## PLANNING CONSULTATION RESPONSE

<b>Application No</b>	2026/0481
<b>Proposal</b>	2026 0481 Variation of Condition 2 (Approved Plans) of 2026 0021 53 Keresforth Hall Road Kingstone Barnsley
<b>Address</b>	53 Keresforth Hall Road Kingstone Barnsley
<b>Date of Consultation Reply</b>	
<b>Consultee</b>	Tony Wiles Senior Conservation Officer

Drawing
 Proposed Lower Ground Floor
 Plan

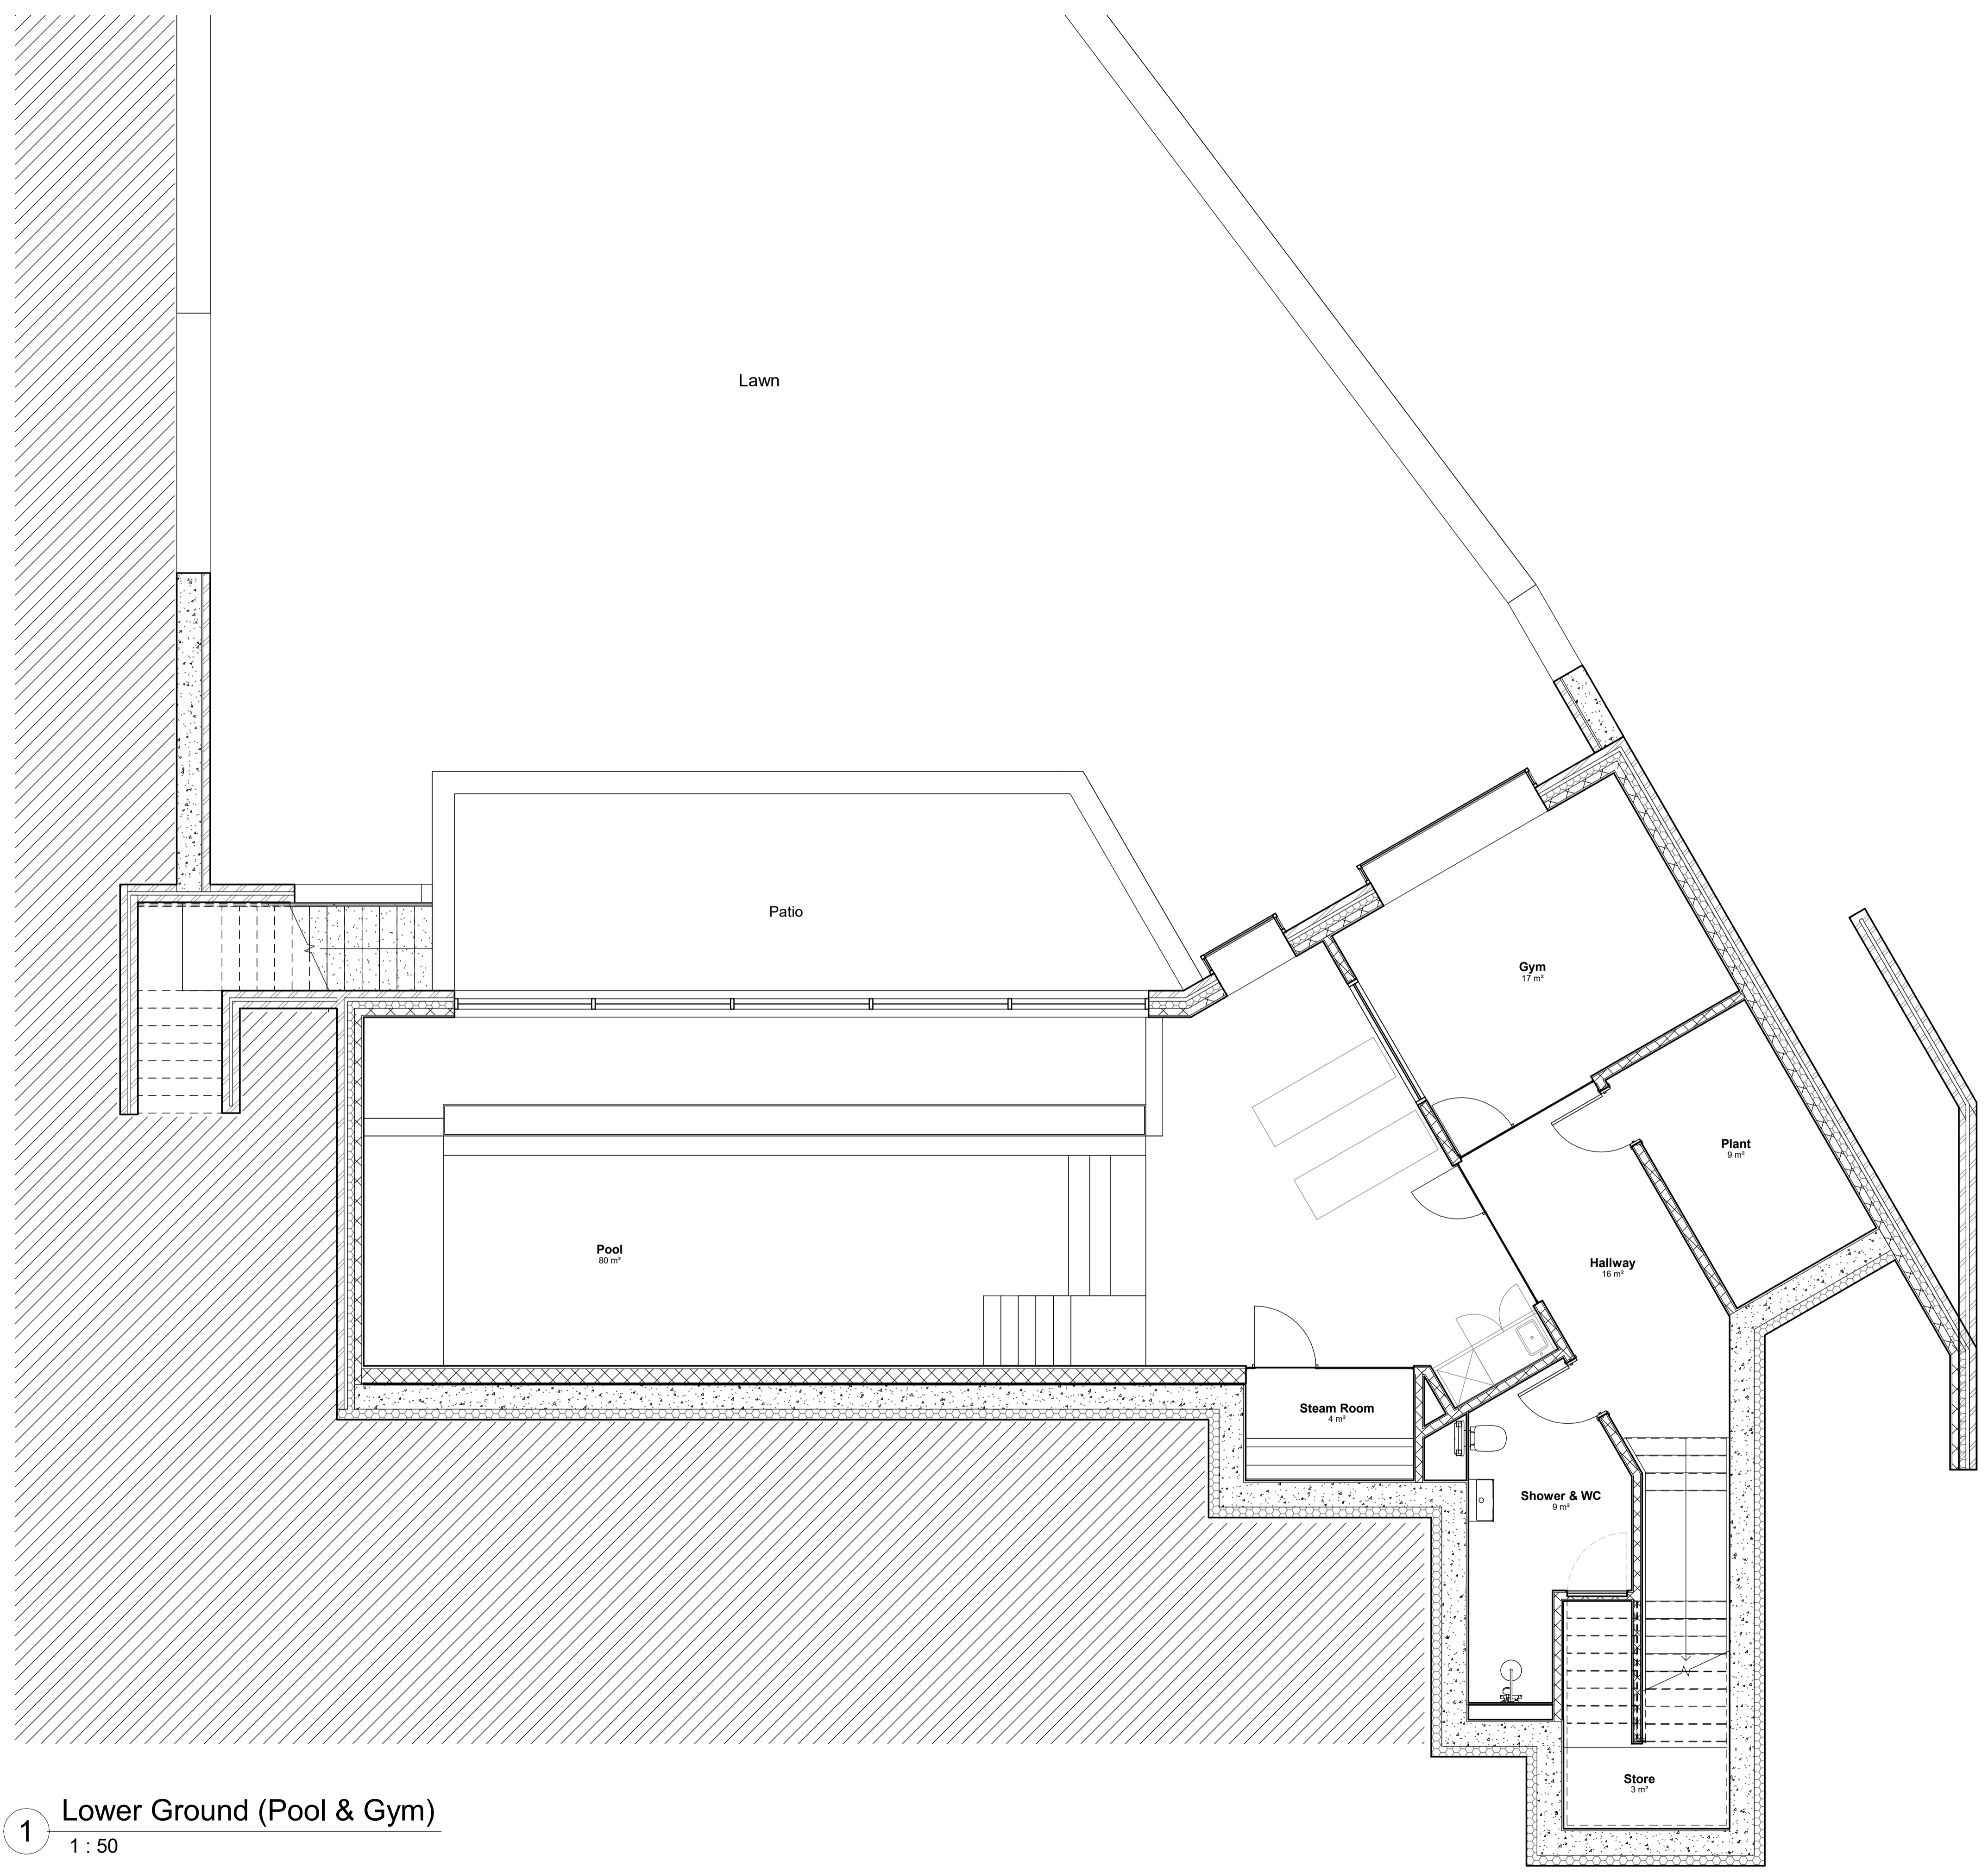
- Alterations to the sub-ground/terrace arrangement, which would extend further to the rear/west and include an angled element orientated due south.

Drawing
 Proposed Visualisation

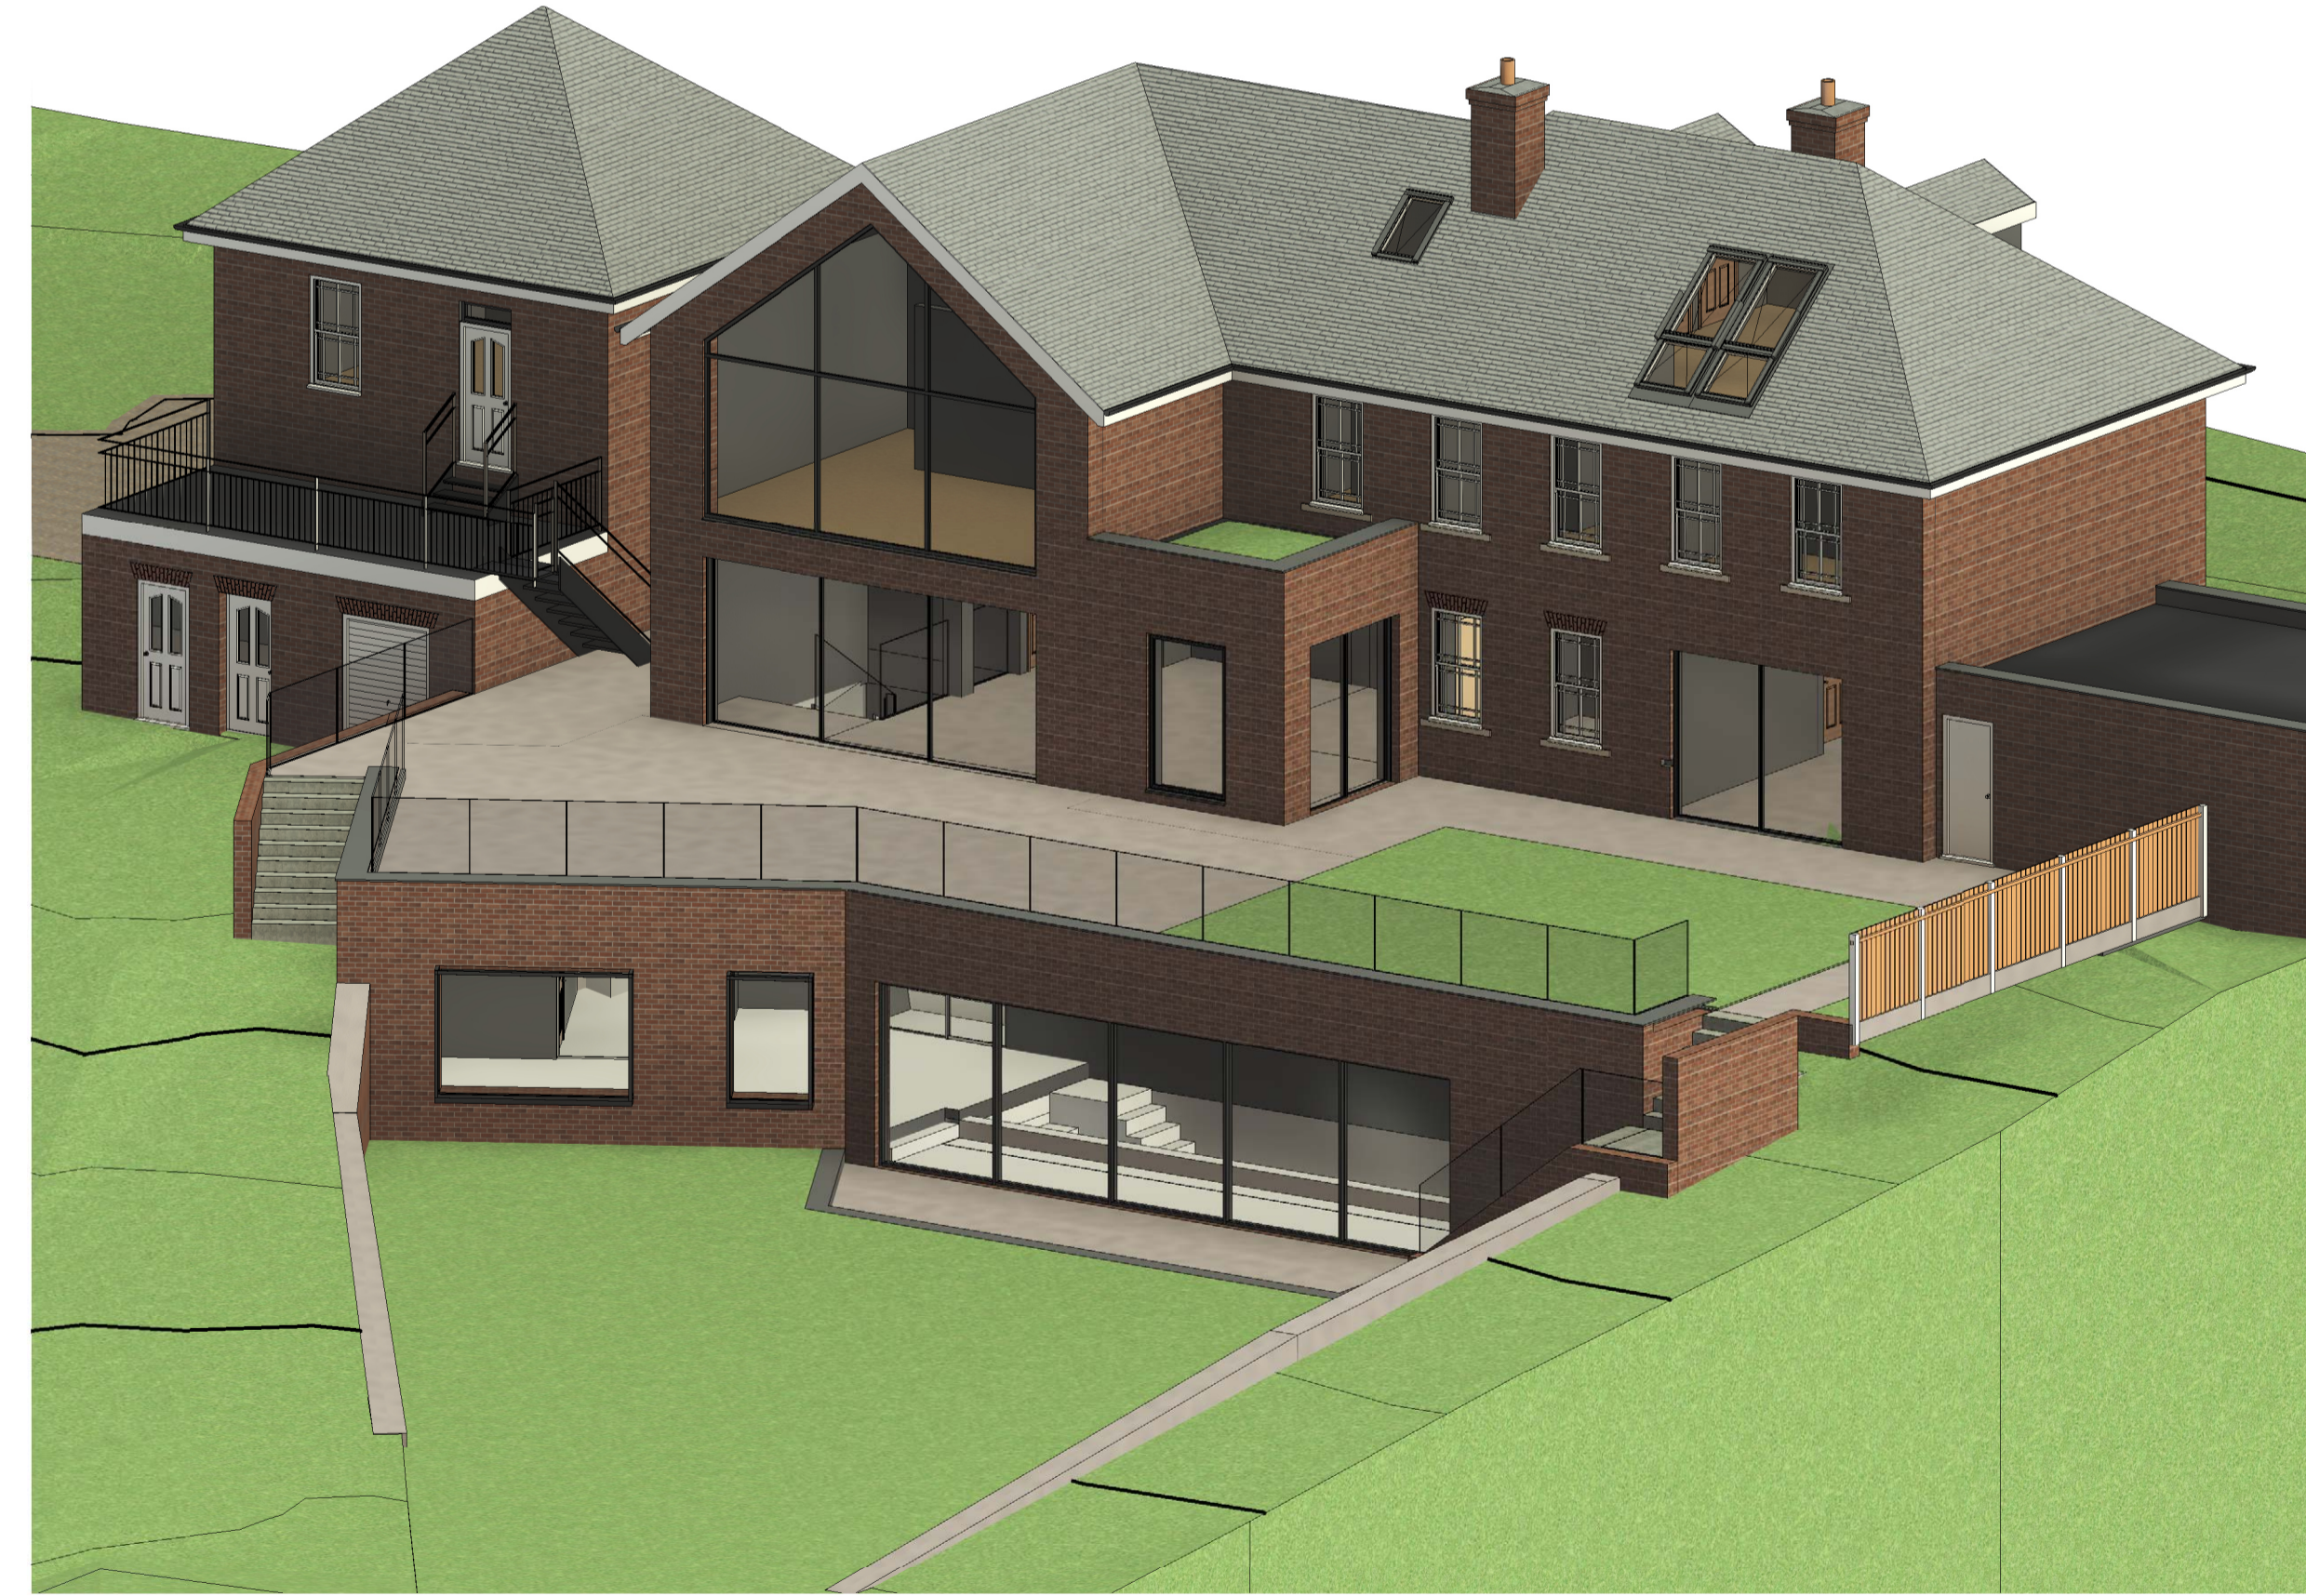
The application seeks approval for a number of amendments to the approved scheme for the development of 53 Keresforth Hall Road. The majority of the proposed changes relate to the rear elevation and rear garden/terrace arrangement, with the exception of the introduction of two gable dormers on the front, roadside roof plane of the principal dwelling. The submitted drawings also identify a number of differences from the previously approved plans at the rear, including:

- Amended fenestration detailing/glazing bar arrangement to the principal glazed rear gable;
- Two additional rooflights, one of which is a larger patent-glazed type;
- A double-leaf sliding door in place of the previously approved single door; and
